Application by Highways England for the A19 Downhill Lane Junction Scheme

The Examining Authority's Written Questions and Requests for Information (ExQ1)

Issued on 20 August 2019

**FIGURE 6.2**

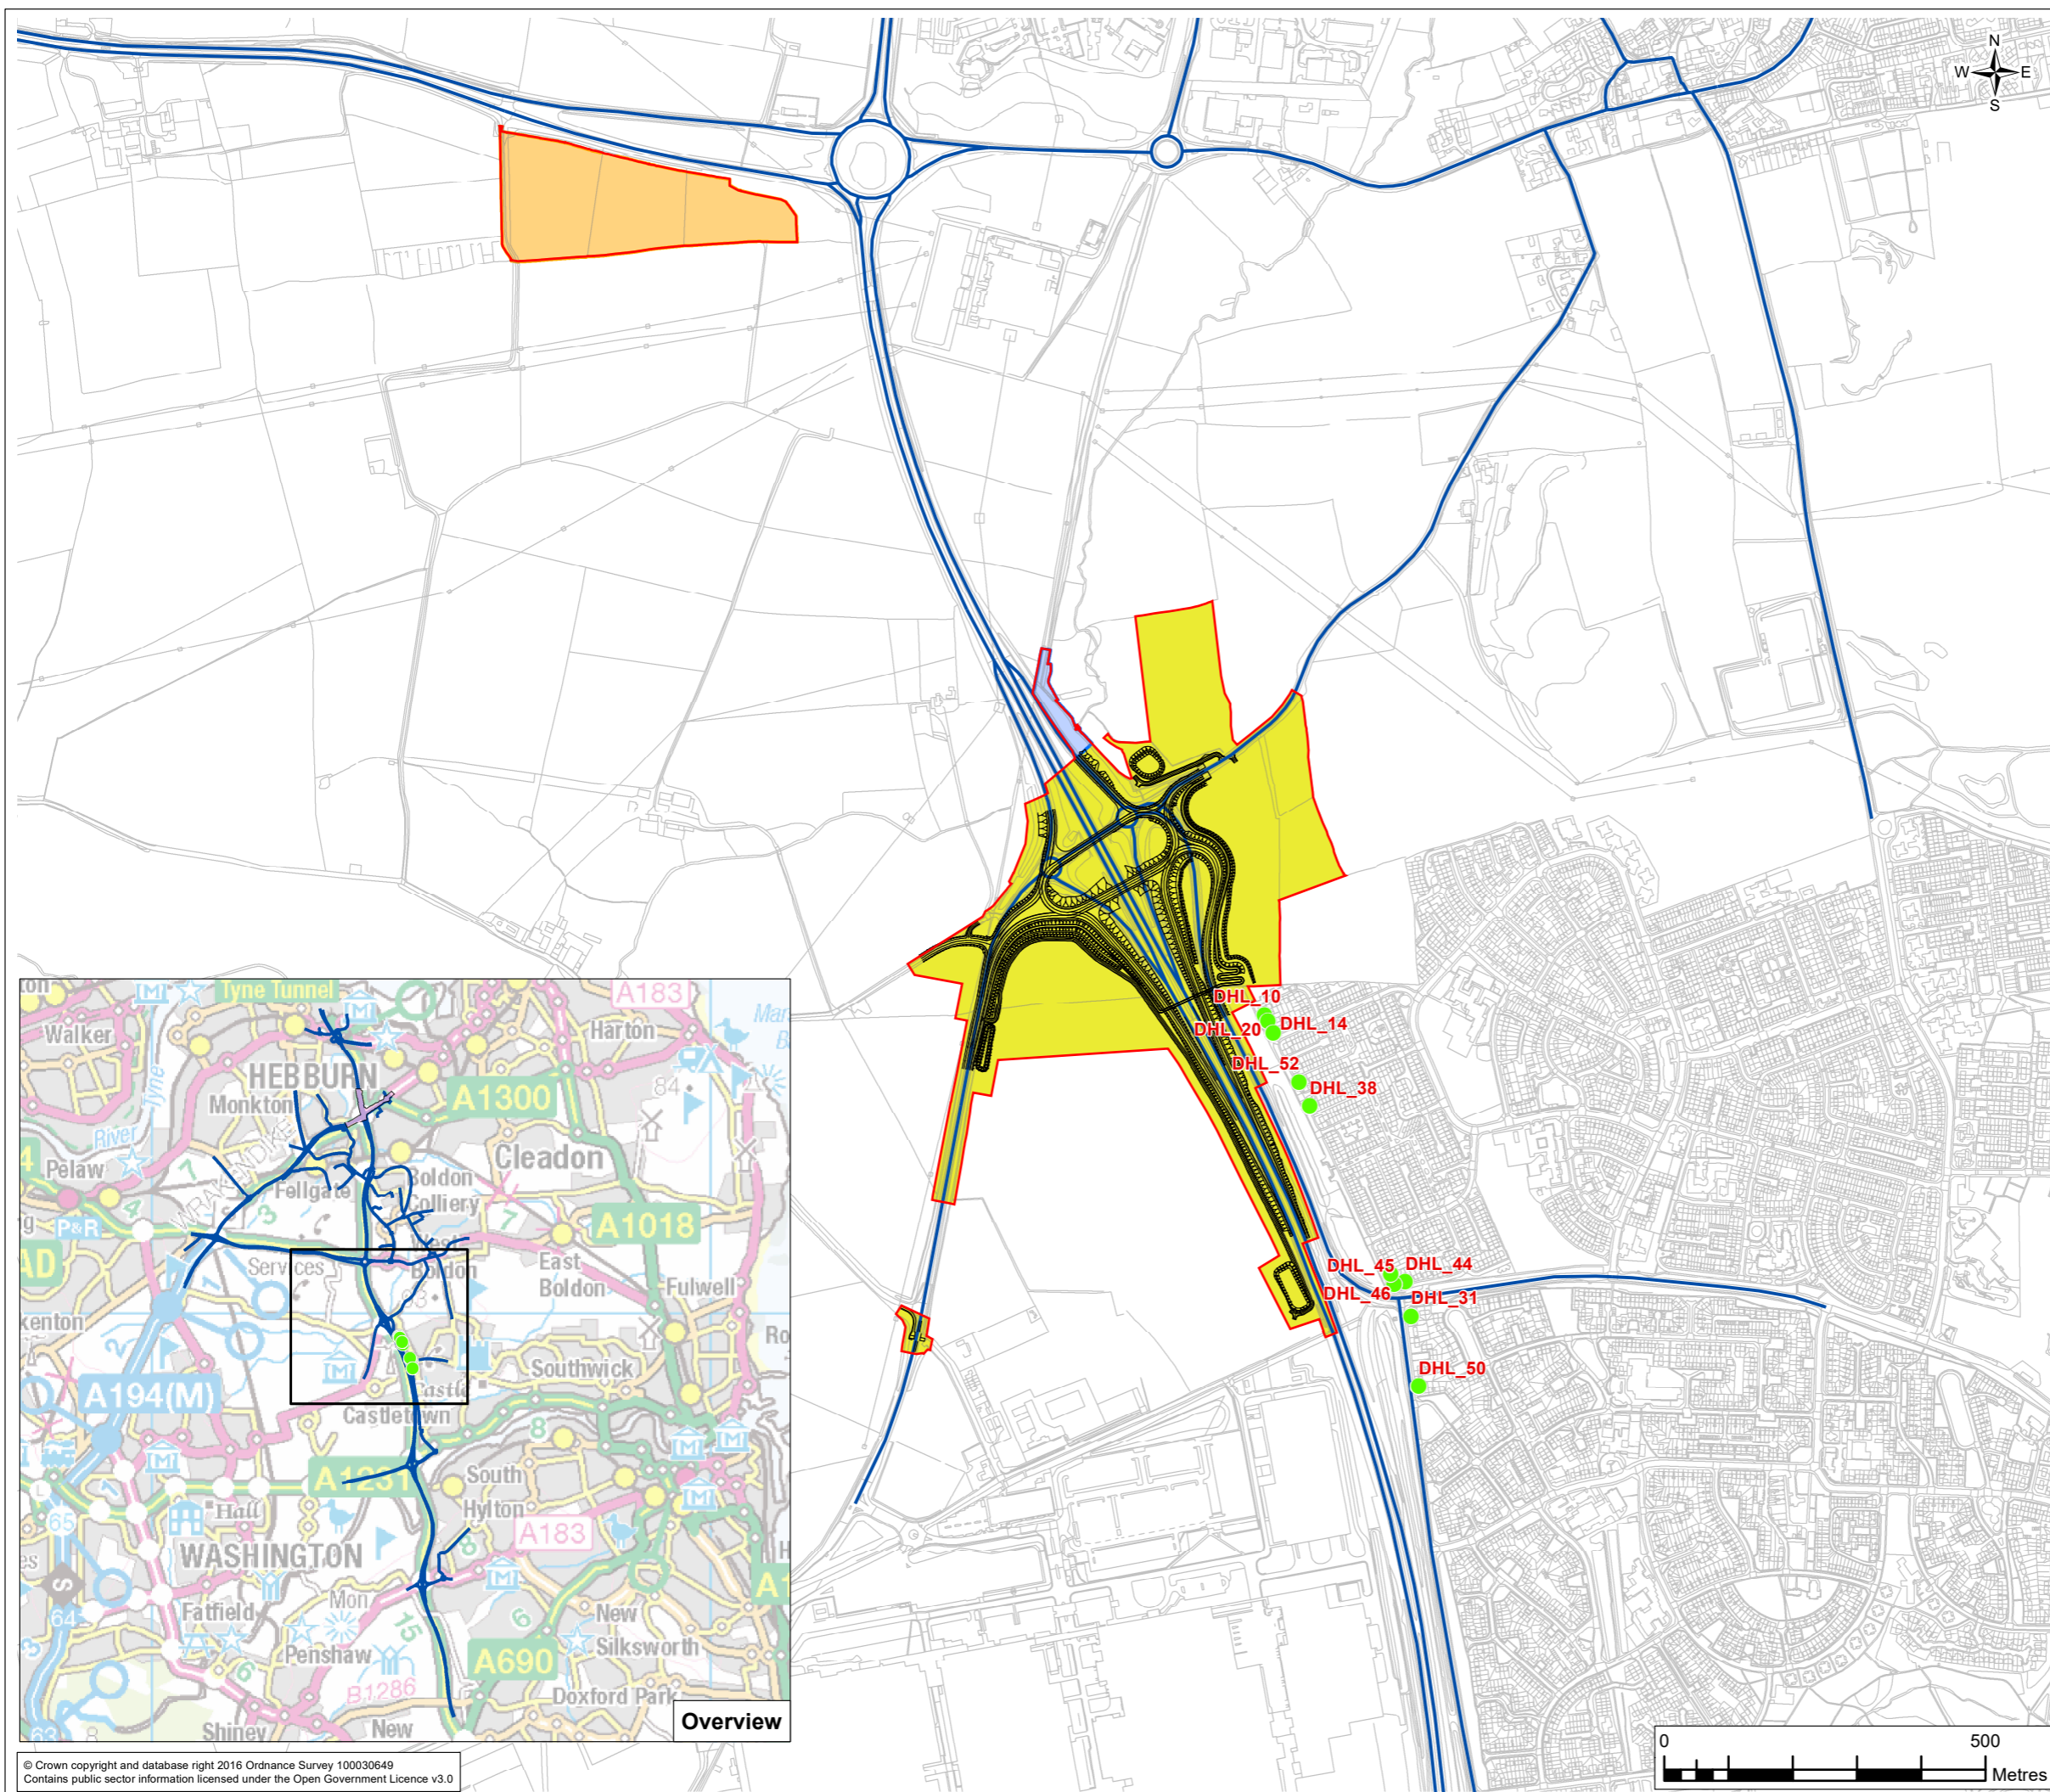
Q1.1.15	Applicant	<p>As set out in paragraph 3.17 of the Scoping Opinion [APP-048], the SoS recommended providing a visual organogram (or similar) of management plans so as to understand the nature of interrelationships across the various plans and topic areas (including reference to their method of delivery within the DCO).</p> <p>The Applicant is asked to provide their response to this request.</p>
2 Air Quality and Emissions		
Q1.2.1	Applicant	<p>Paragraph 6.3.7 of the ES [APP-020] states that the study area for the assessment of air quality was defined by identifying all sensitive receptors 200m from the affected road network. Paragraph 6.3.9 refers to Figure 6.1 [APP-023] indicating that it illustrates the air quality study area and constraints and that the study area covers the Downhill Lane junction, sections of the A19 and sections of the A1290. Figure 6.1 shows the modelled road network whilst Figure 6.2 and subsequent figures show the position of 10 receptors with the highest</p>

Ref No.	Respondent:	Question:
		<p>concentrations within Table 6.5-a in Appendix 6.5 [APP-33] identifying all 55 receptors.</p> <p>The Applicant is asked:</p> <ul style="list-style-type: none"> • to clarify how the 55 receptors were identified and to show them on a plan to enable the study area boundary to be mapped; • to clarify how the modelled road network was identified and whether this is different from affected roads; • with respect to Figure 6.1 to show the affected road links which the key indicates are shown as red or green in colour but do not appear to be shown other than a short stretch of Washington Road - is this because there would be no affected roads subject to an increase in traffic?; and • to explain why the modelled road network includes only Washington Road and Ferryboat Lane within the quadrant to the south east of the application site.
Q1.2.2	Applicant	<p>Paragraph 6.3.17 of the ES [APP-020] states that background concentrations for NO_x, NO₂ and PM₁₀ were calculated. Paragraph 6.1A.8 of Appendix 6.1 also identifies these pollutants as relevant to the assessment.</p> <p>On what basis were these pollutants identified as being relevant?</p>

FIGURE 7.1

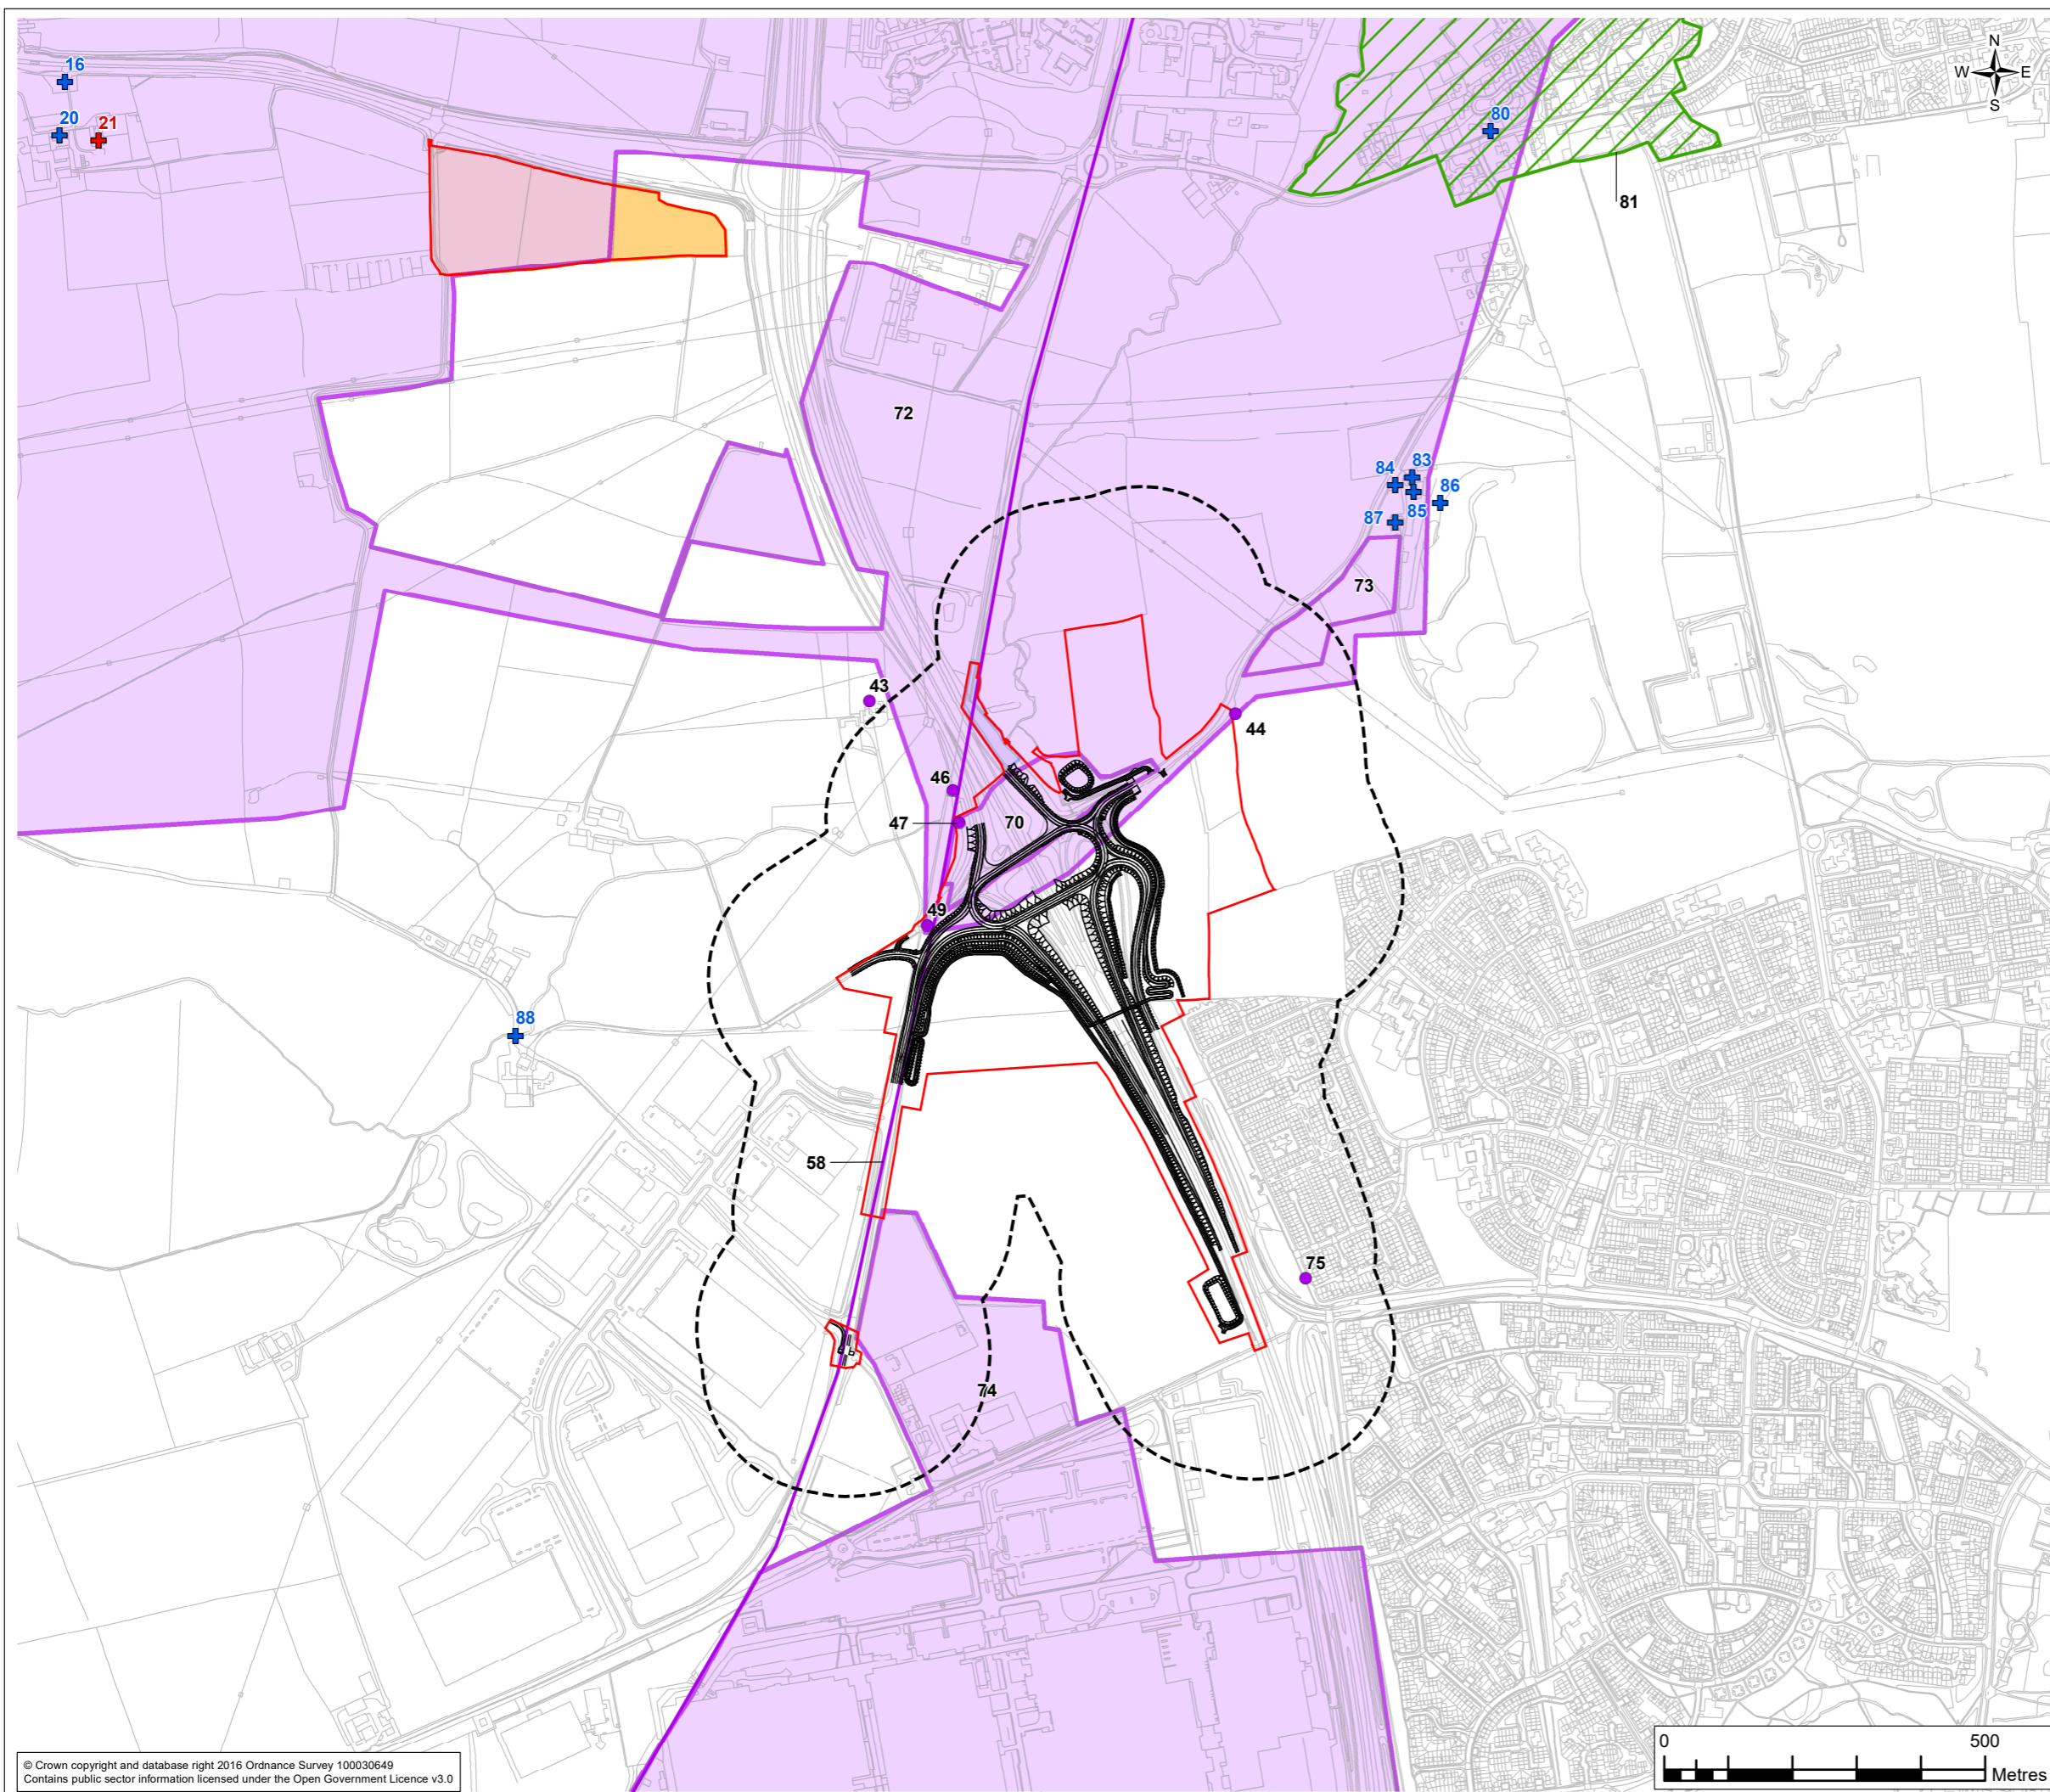
Ref No.	Respondent:	Question:
Q1.7.3	Applicant	<p>Paragraph 7.3.9 of the ES [APP-020] states that at the time of writing a response had not been received from the County Historic Buildings Officer.</p> <p>Has there been any subsequent response from the County Historic Buildings Officer?</p>
Q1.7.4	Applicant	<p>Reference is made in paragraph 7.3.11 of the ES to the 2015 Historic England guidance 'Historic Environment Good Practice Advice in Planning Note 3: The Setting of Heritage Assets'. The Second Edition of the advice was published in 2017.</p> <p>Has this been taken account of? Does it change any of the study's findings?</p>
Q1.7.5	Applicant	<p>Paragraphs 7.5.18 - 7.5.20 of the ES [APP-020] identify various listed buildings by asset number. Whilst the listing descriptions are included in Appendix 7.3 [APP-034] they do not appear to be shown on Figure 7.1.</p> <p>The Applicant is asked to amend Figure 7.1 to include the assets which have been omitted.</p>
